**Consultation Response from KC, Conservation & Design**
**2022/92081 Land at, Huddersfield Road/Leeds Road, Birstall, Batley, WF17 9AA**
**Demolition of existing buildings and erection of retail food store with associated parking and landscaping**
**Date Responded:**
**Responding Officer:**
**Responding Ref:**

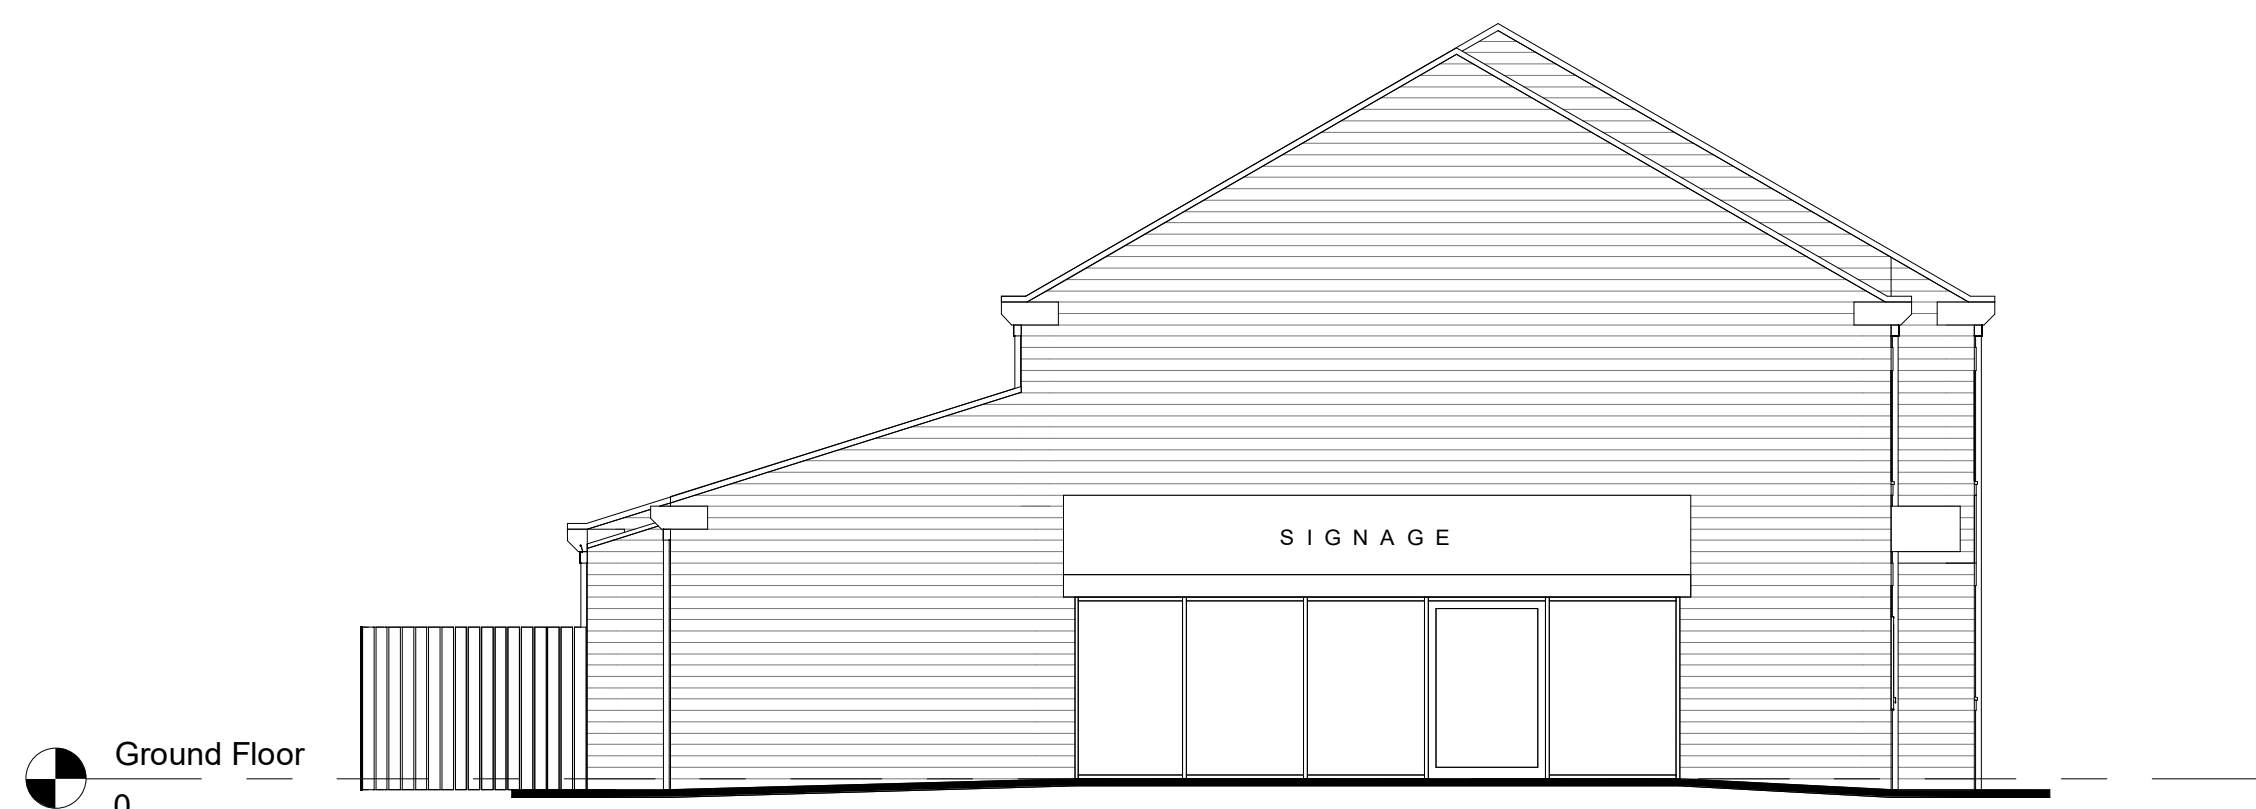
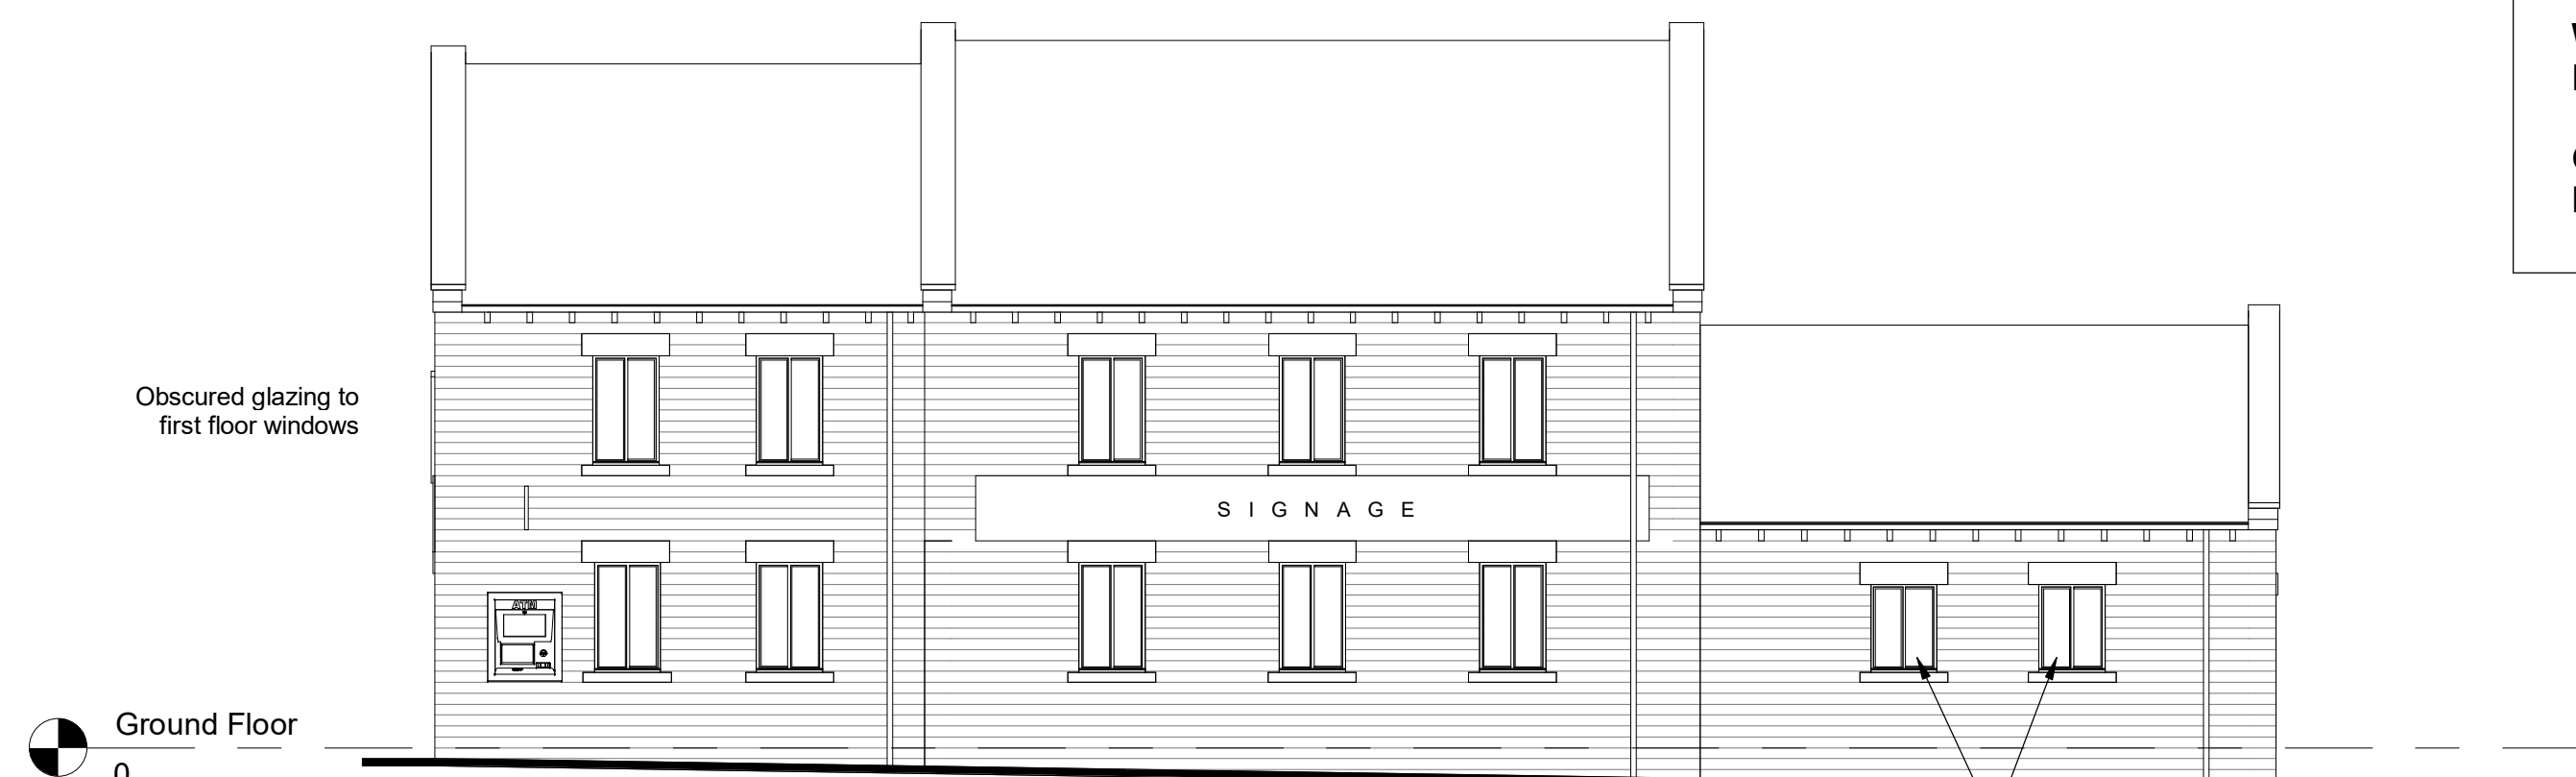
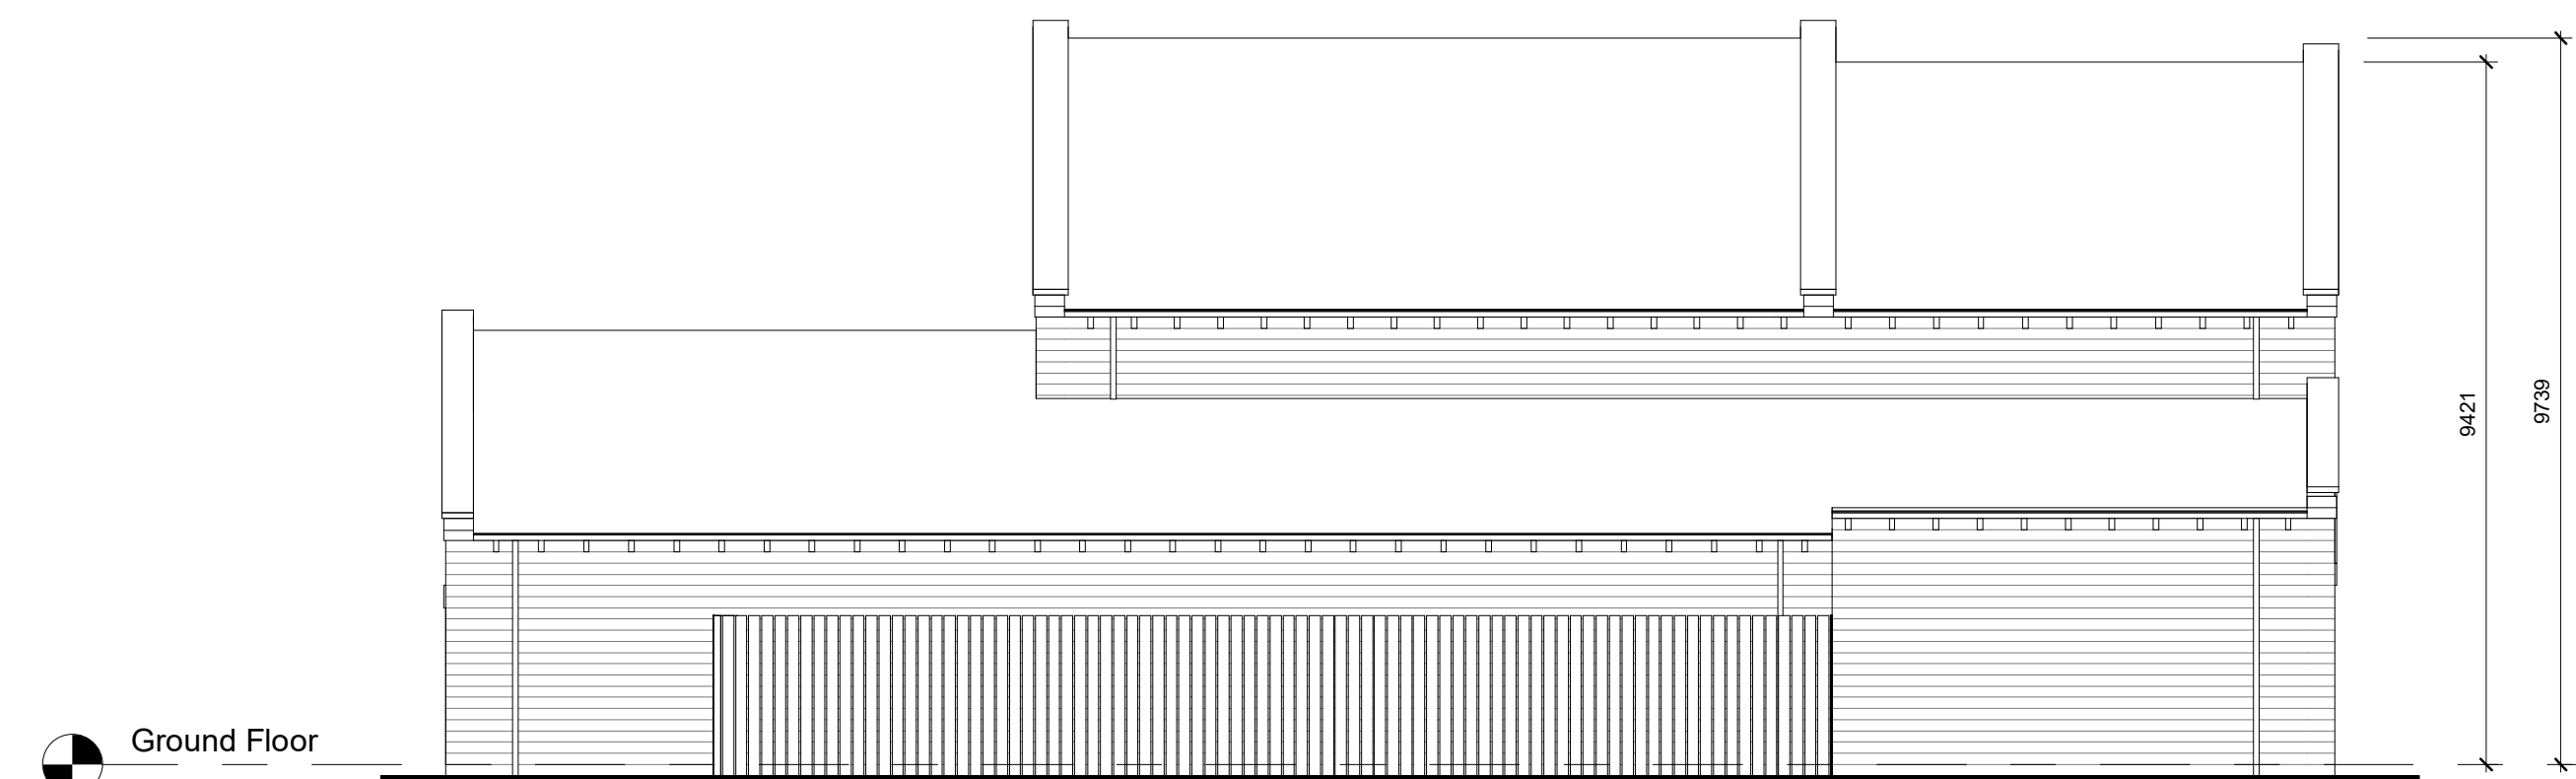
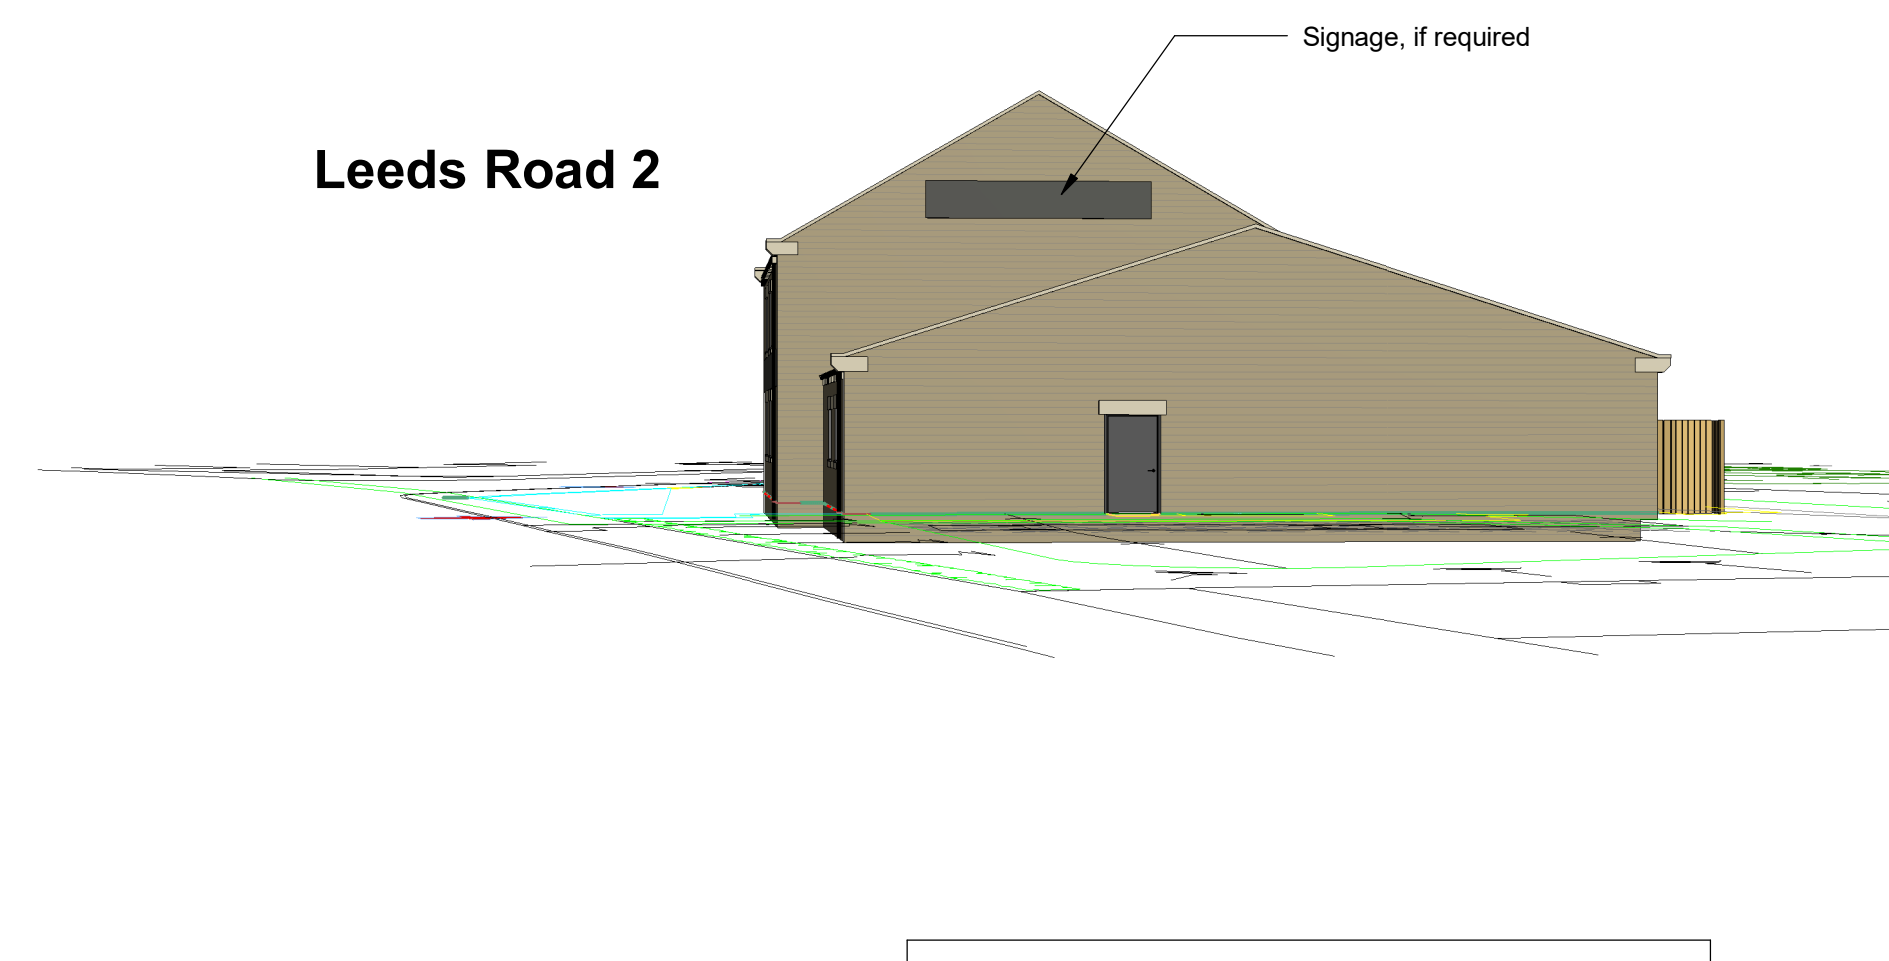
We do however have concerns in respect to the detail of the proposed replacement building. We consider that the building should be exclusively constructed from coursed, or hammer dressed stone, no use of ashlar, which is not characteristic of the area. We are also not supportive of the use of the ashlar quoins.

The roof should be amended for it to be finished in stone slates apposed to blue slates, which are not representative of the character of the area.
